**KIRKLEES METROPOLITAN COUNCIL  
INVESTMENT & REGENERATION SERVICE**

**DELEGATED DECISION TO DETERMINE PLANNING APPLICATIONS**

Reference No:	<b>2023/62/93708/E</b>
Site Address:	36, Trueman Avenue, Heckmondwike, WF16 9JX
Description:	Erection of two storey extension to side and dormer window to rear
Recommending Officer:	Elenya Jackson

## **OFFICER REPORT: 2023/93557**

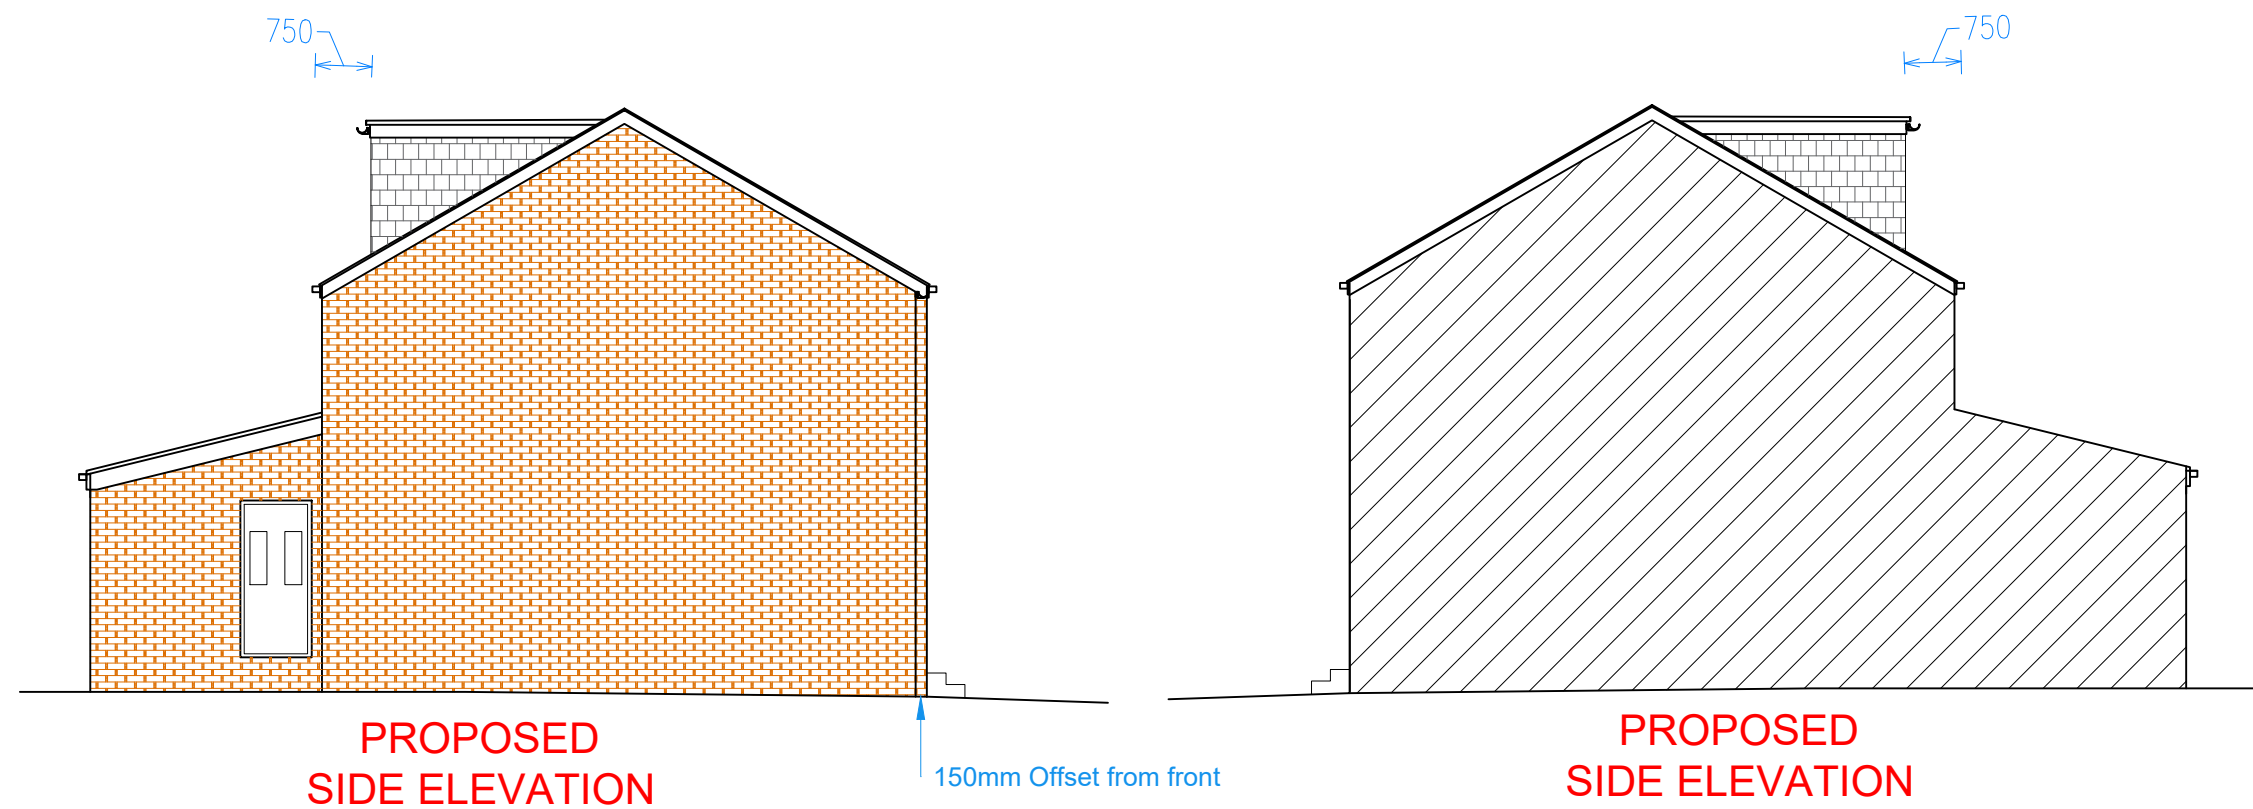
The two storey side extension would extend 2.5m beyond the side elevation of the dwelling and have a depth of 7.8m with a maximum height of 7.6m and an eaves height of 7.4m. This would be set down and back from the host dwelling by 150mm.

The rear dormer would project 3m beyond the roof plane of the host dwelling with an eaves height of 1.8m.

The proposal was initially received with a front dormer which officers requested was removed.

The proposal would be set down and back from the host dwelling (although not the extent set out within the SPD) and due to the spacing provided at the side of the dwelling would be of limited width in the context of the host dwelling. It is acknowledged that the proposal would not allow for 1m gap, nor would be set back by 500mm from the front elevation of the host dwelling, however from a visual perspective, it is considered that the proposal would not appear dominant to the host dwelling. In addition, the applicant has removed the front dormer from the proposal.

The rear dormer would not be overly prominent from the public realm, would be contained within the roof space of the host dwelling and constructed out of matching materials.

*Impact on 38 Trueman Avenue:* adjoins the application site to the east.  
Overlooking: The proposal would not feature any side facing windows and therefore would not result in a loss of privacy to the occupants of no.38.  
Overshadowing/loss of light/overbearing: The proposed extension would be located to the south west of no.38, would not increase the maximum height of the dwelling or extend beyond the principal or rear elevations of the dwelling. The proposal also would not be situated within the vertical 45 degree visibility splay of any windows at no.38. In addition, No.38 is elevated in relation to the

Overlooking: The dormer would be contained within the roof space of the host dwelling and the two storey extension would be screened by the host dwelling. Therefore no significant issues would arise regarding the residential amenity of the occupiers of no.34.
